City of Portland, Maine - Building or Use Permit Application
 389 Congress Street, 04101 Tel: (207) 874-8703, Fax: (207) 874-8716

Permit No: 03-0713	Issue Date: JUN 19 2003	CBL: 386A B030001
-----------------------	----------------------------	----------------------

Proposed Use:	Proposed Project Description:
Single Family	Amend permit #02-1323 to finish off basement w/2 bedrooms/bath/game rm

Dept: Building Status: Approved with Conditions Reviewer: Jeanine Bourke Approval Date: 06/19/2003

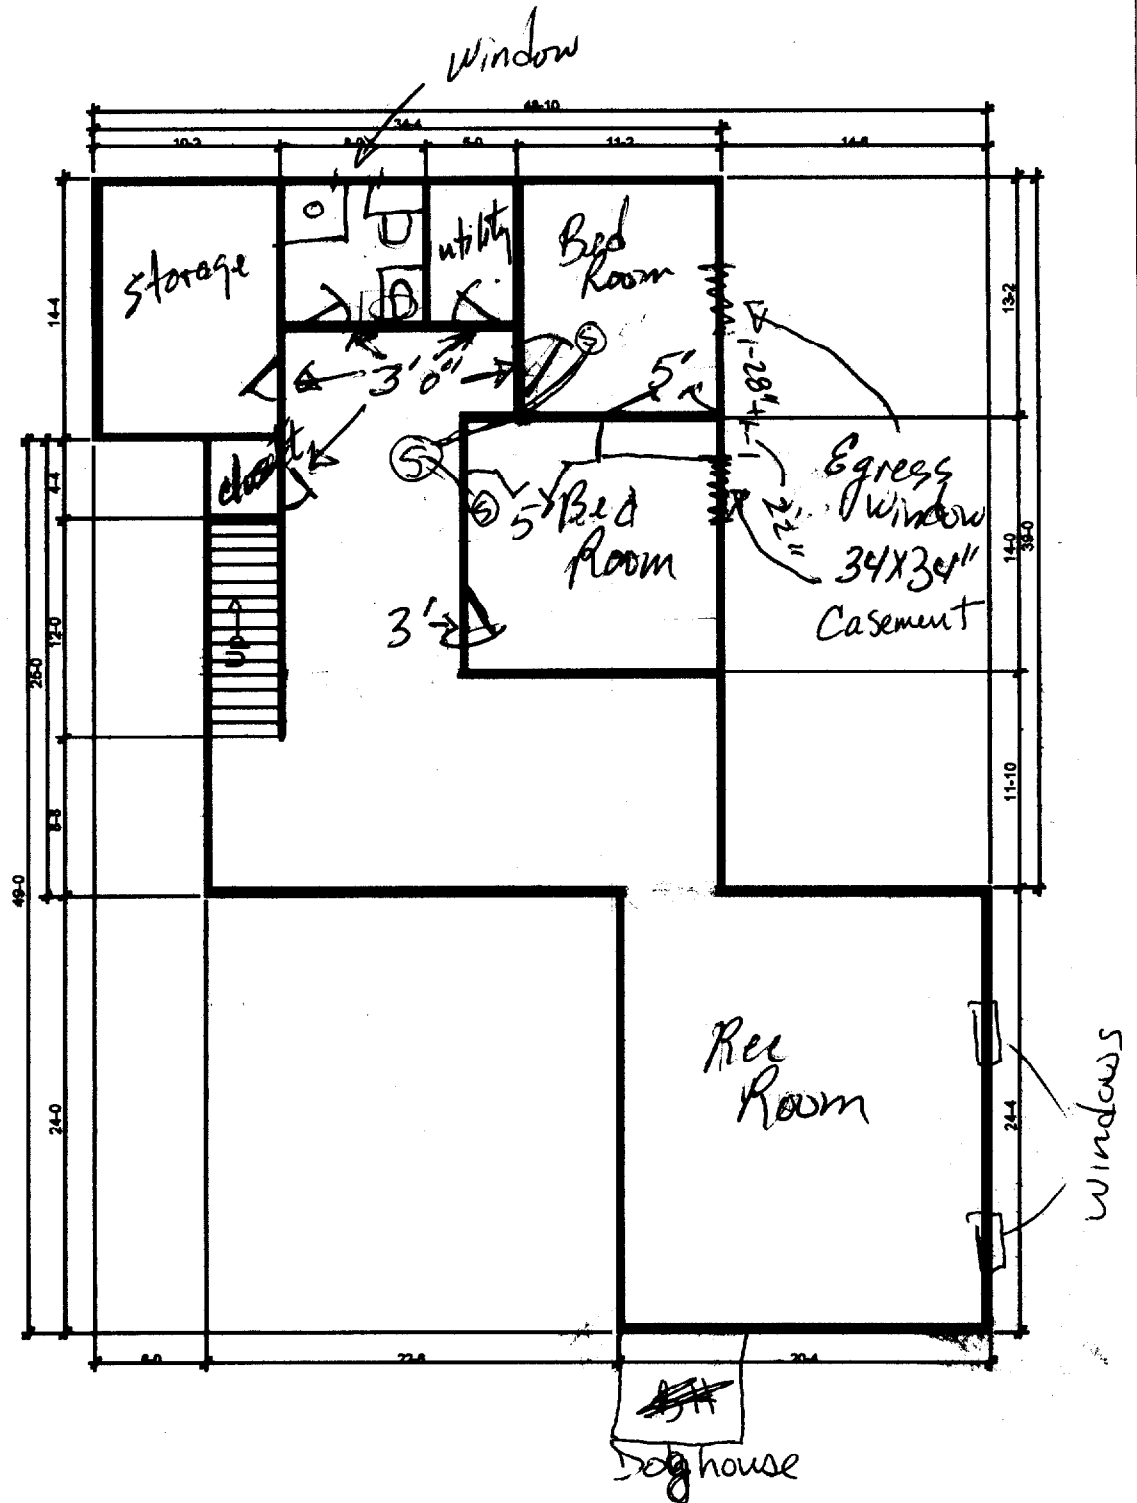
- 1) The mechanical room must be provided with adequate combustion air for circulation
- 2) The egress windows in the new bedrooms need to meet 5.7 sf. And if the distance from the floor to the clear opening is more than 44" a permanent step must be installed. This step must not exceed 7-3/4" rise and be a min. Of 10" tread.
